**Wallahah 2 Coal Project (SSD 4974)
Environmental Impact Statement Review**

NSW Trade & Investment, Regional Infrastructure & Services, Division of Resources & Energy (DRE) has reviewed the *Wallahah 2 Coal Project Environmental Impact Statement* (EIS) dated April 2013 and provides the following comments which are directed at specific areas of DRE responsibility for this proposal.

**Figure 4.2 Current layout showing areas of various extraction heights**

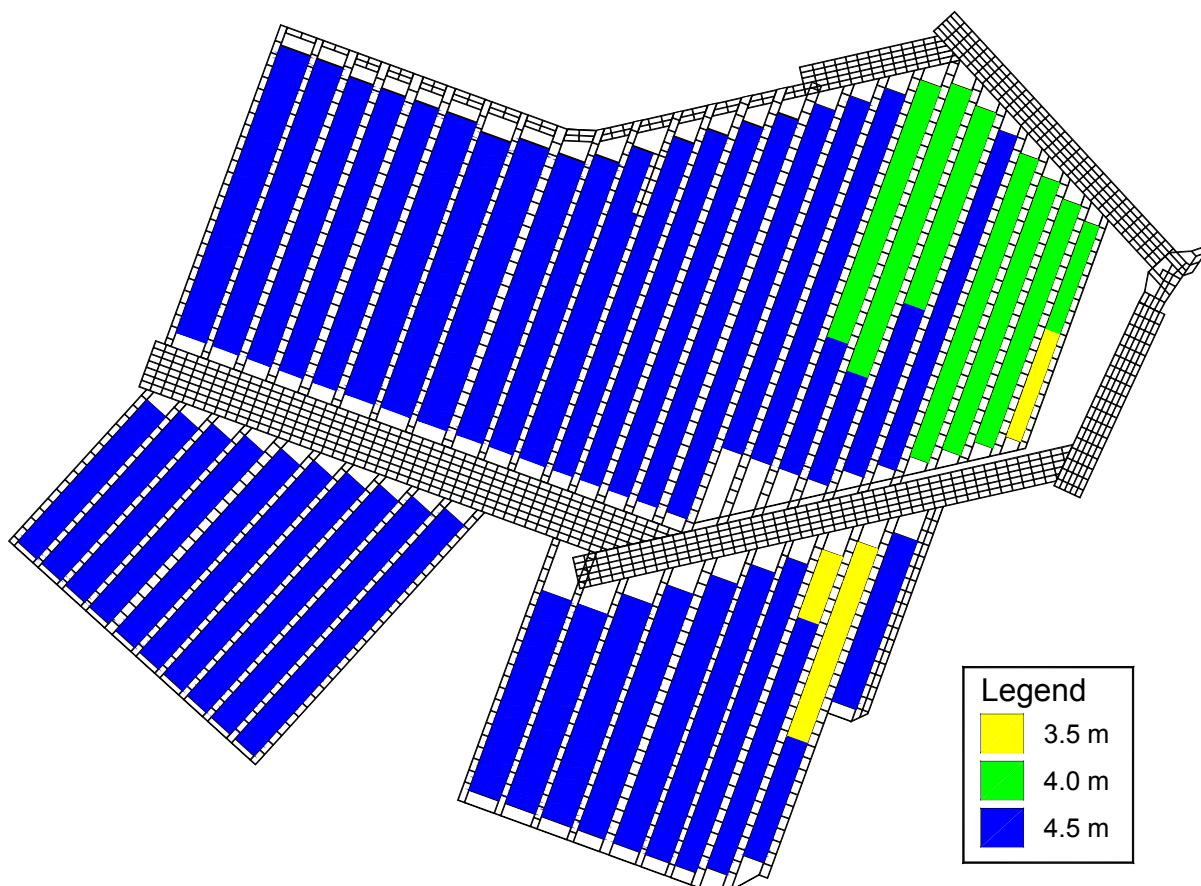
There is a need to consider flexibility in mine layout design, to respond to any unexpected impacts or difficulties in implementing the proposed mitigation and management measures.

Similar to flood impacts, there is a need to consider flexibility in mine layout design, to address unexpected impacts or potential difficulties in implementing the aforementioned property subsidence management plans.

Figure 5.6 Predicted Total Subsidence Contours

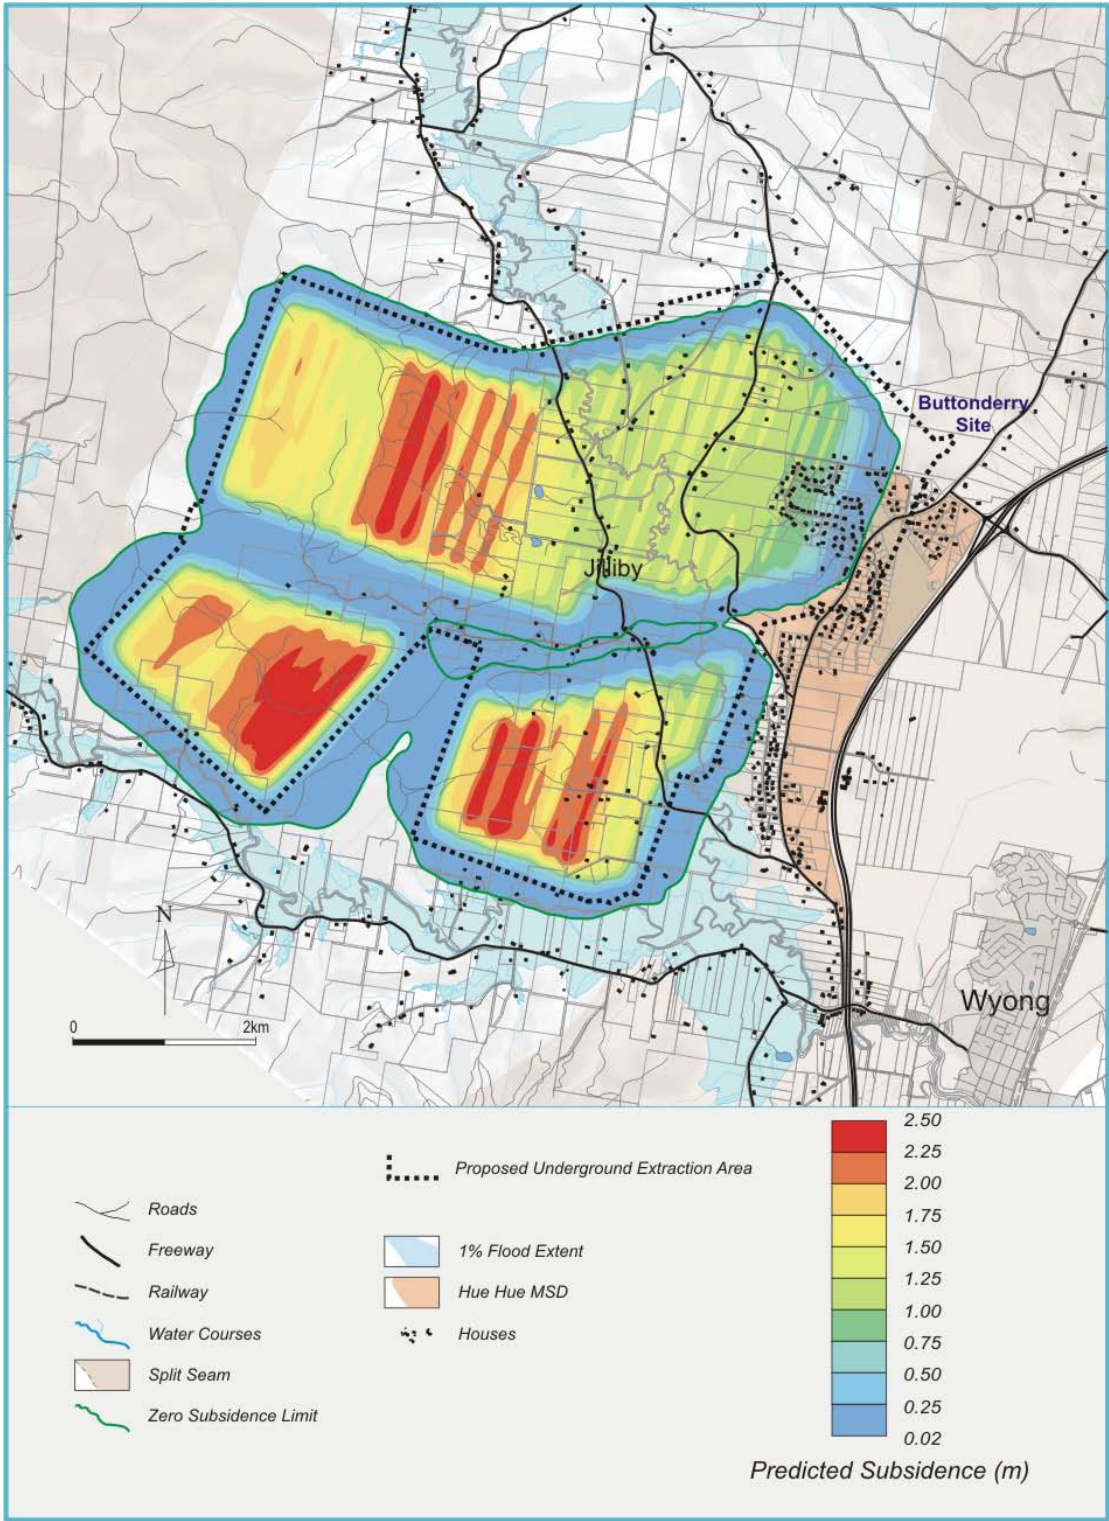
The site of the proposed mining is entirely within the Hue Hue and Wyong Mine Subsidence Districts (MSD). The proponent has designed the mine layout in an attempt to limit subsidence movements in the Hue Hue MSD to within the limits ascribed to this MSD. No such design limits have been ascribed and applied to the Wyong MSD.

The EIS indicates 245 houses in the project area may be affected by the proposed mining of which it is expected that 43 will be damaged to a degree that requires repair, including a number that may be substantially damaged.
